Harnett County Government Complex  
307 W. Cornelius Harnett Boulevard  
Lillington, NC 27546

September 11, 2018

**Re: Status of Improvement Permit Application and New Well SFD #1808-0034**  
**Location: 230 Antioch Church Rd.**

PROJECT:	18-160	FOR:	TIMOTHY F. & CANDISE W. COWAN
DRAWN BY:	CLM	ANTIOCH CHURCH RD, DUNN, NC 28334 DUKE TWP., HARNETT CO., N. C. DB: 3597, PG: 887, PIN: 0895-86-6945.000	
SCALE:	1"=30'	PRELIMINARY PLOT PLAN	
DATE:	08-22-2018

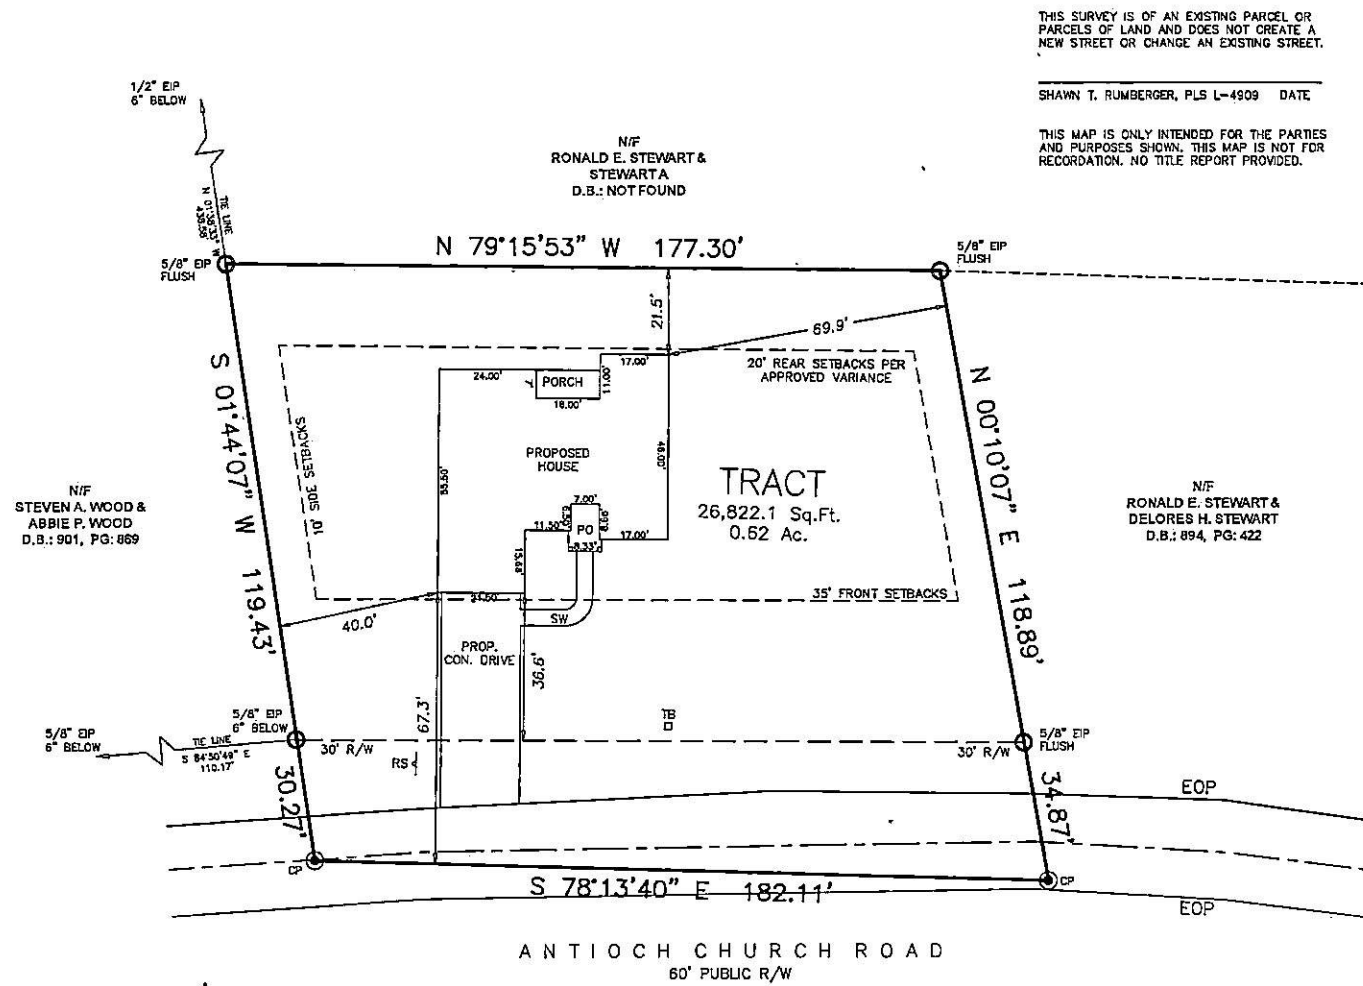
- 1. Use pink flags to mark property lines and irons that are set by surveyor need to be visible *(\$25.00 fee incurred)*
- 2. Use orange flags to mark house corners *(\$25.00 fee incurred)*
- 3. Directions not clear to property *(\$25.00 fee incurred)*
- 4. Property needs only brush or vegetation removed
- 5. Driveway not shown on site plan
- 6. Backhoe pits required
- 7. Other – Lot placed on hold. Applicant stated that land is pending to be recombined with adjacent lot. Post-recombination site plan shall be revised and readdressed with new setbacks and site survey. Coordinate revisions with Central Permitting.**
